WEST SUSSEX COUNTY COUNCIL CONSULTATION

TO:	Arun District Council FAO: Nicola Moore
FROM:	Alison Meeus, WSCC, Highways
DATE:	11/12/2018
LOCATION:	Maypole Lane, Land at Long Acre
SUBJECT:	<u>Y-92-18</u> Approval of details reserved by condition imposed under ref Y/92/15/PL relating to condition 4 & 6 4 – Construction Management Plan 5 – Scheme of improvements 6 – Travel Plan Statement
DATE OF SITE VISIT:	n/a
RECOMMENDATION:	☐ Advice ☐ Objection ☐ Modification ☐ No Objection ☐ More Information ☐ Refusal
S106 CONTRIBUTION TOTAL:	£ See below for breakdown.

N:\Projects\cnbam 141103\Drawings\141103-05_06 [Maypole Lane Proposed Highway Work].dwg

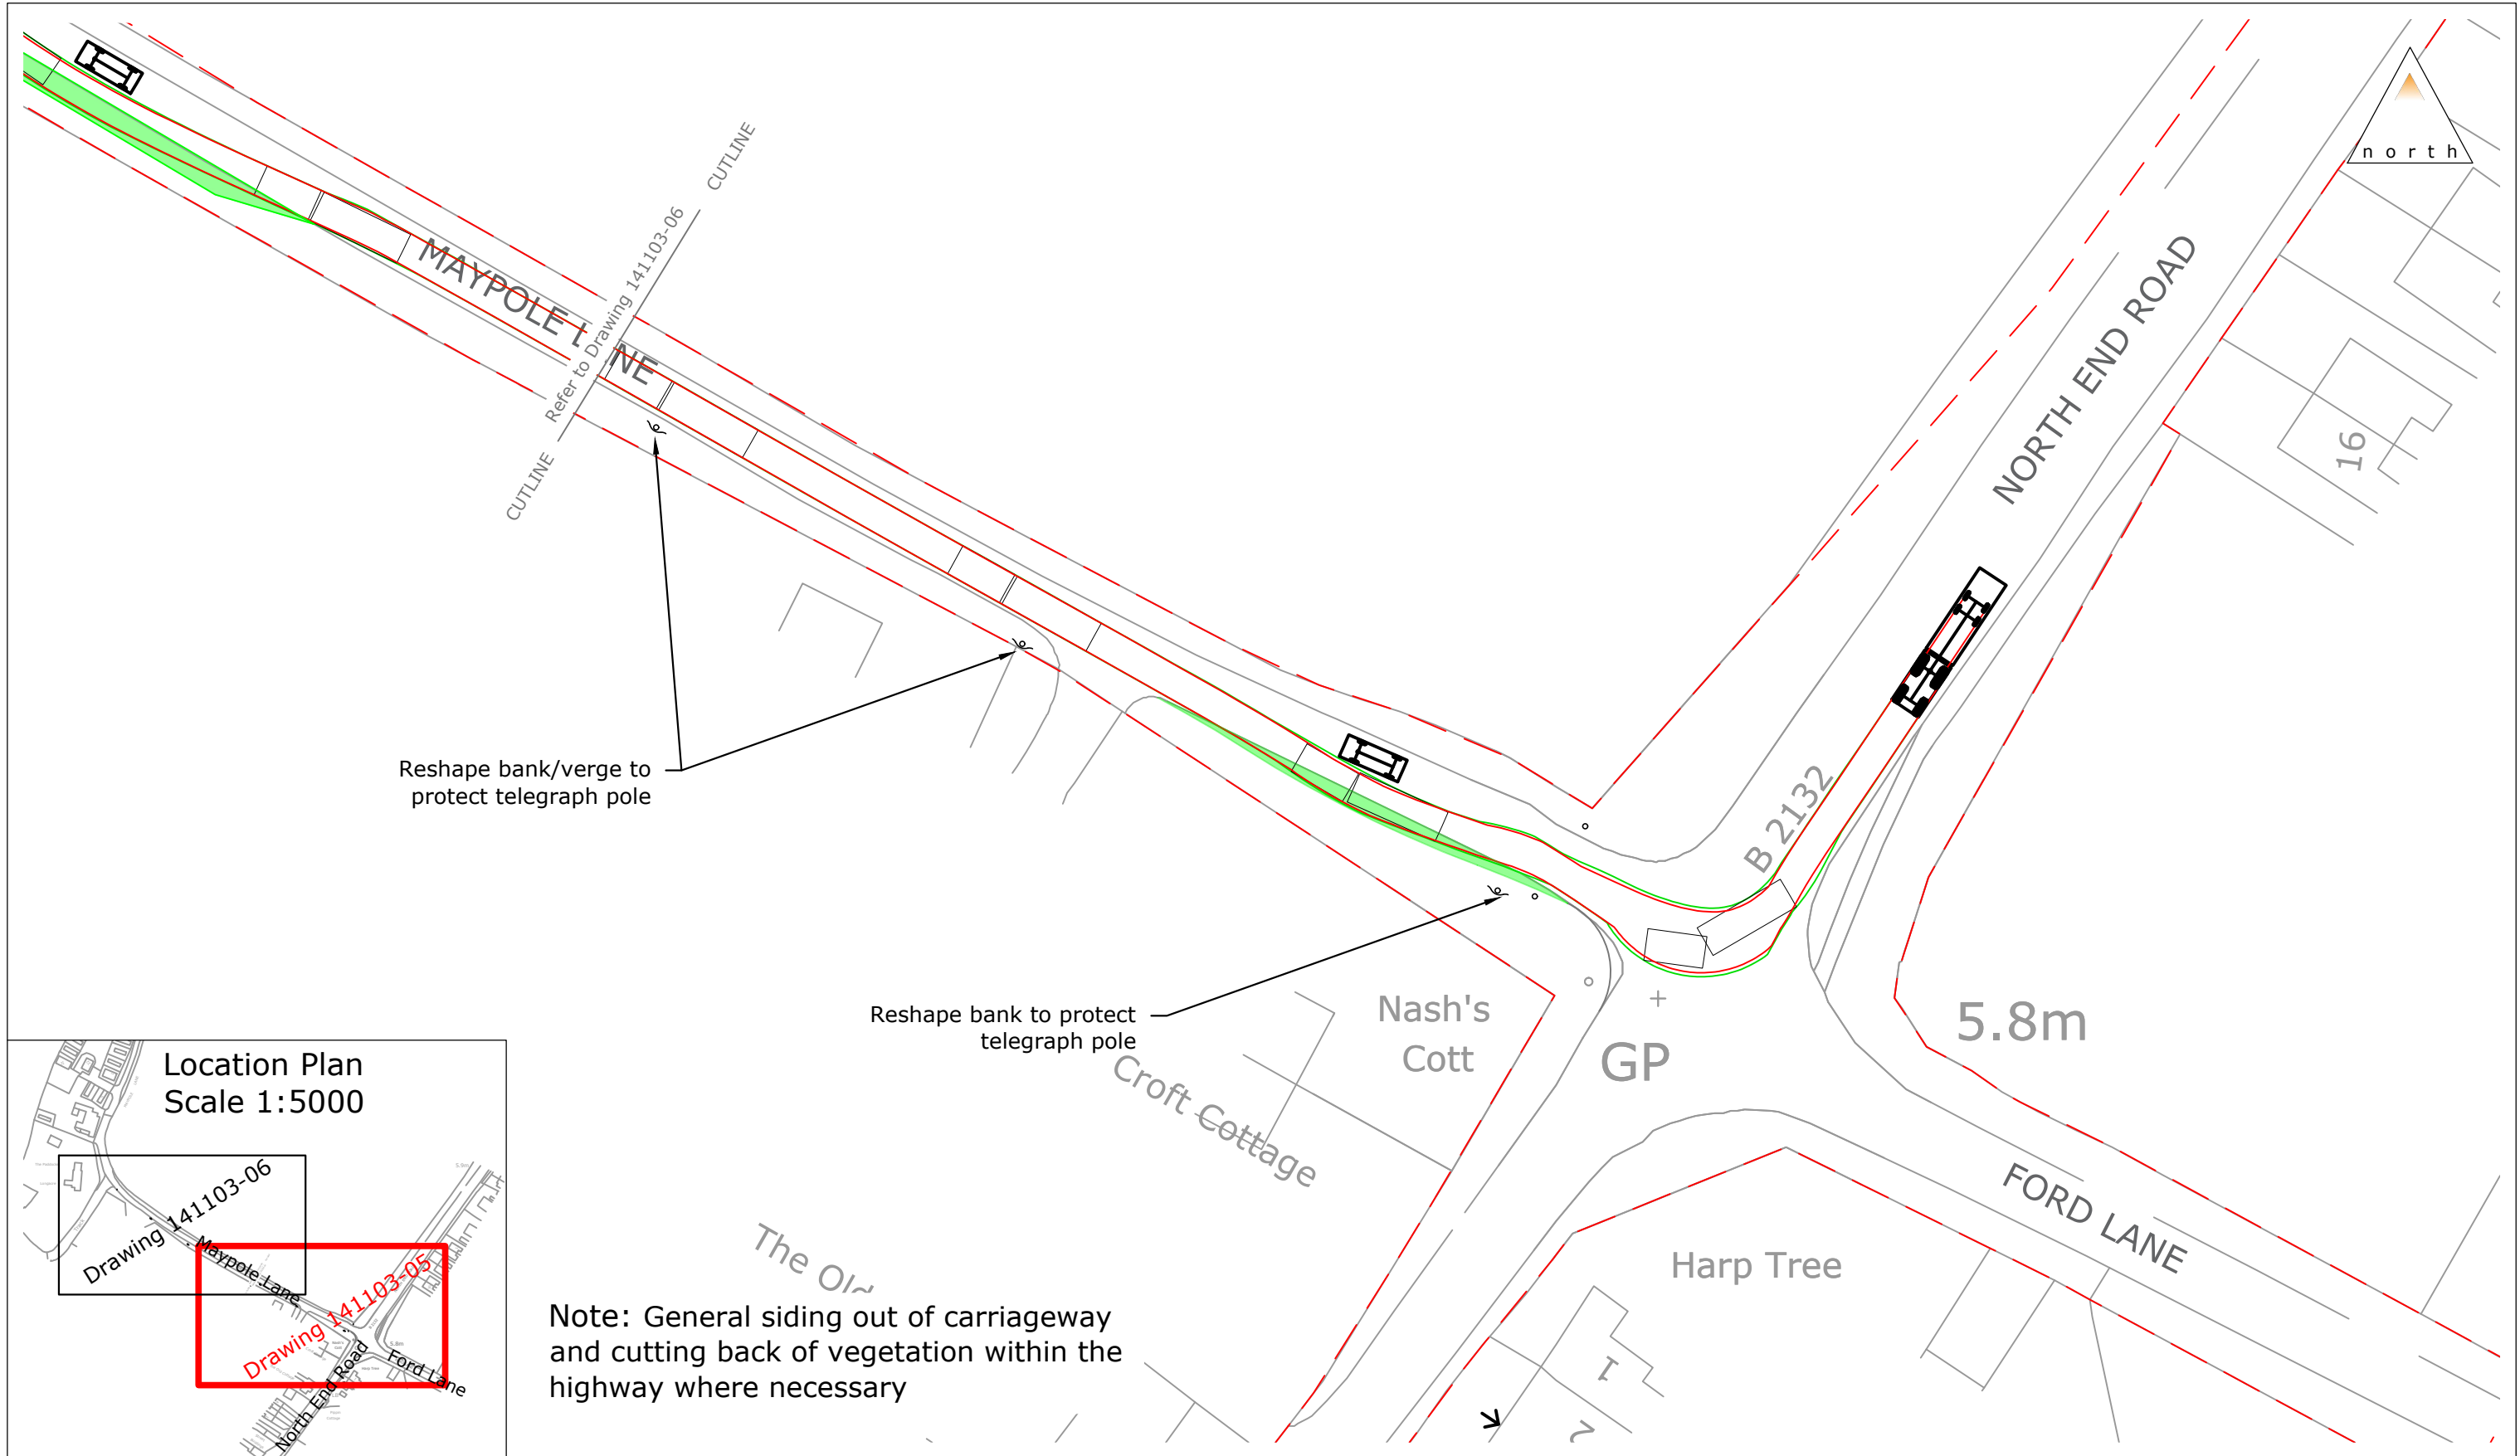
These plans can be discharged and should be sent to the Area Office contact above to progress a MWA to tie in with the end of the construction phase.
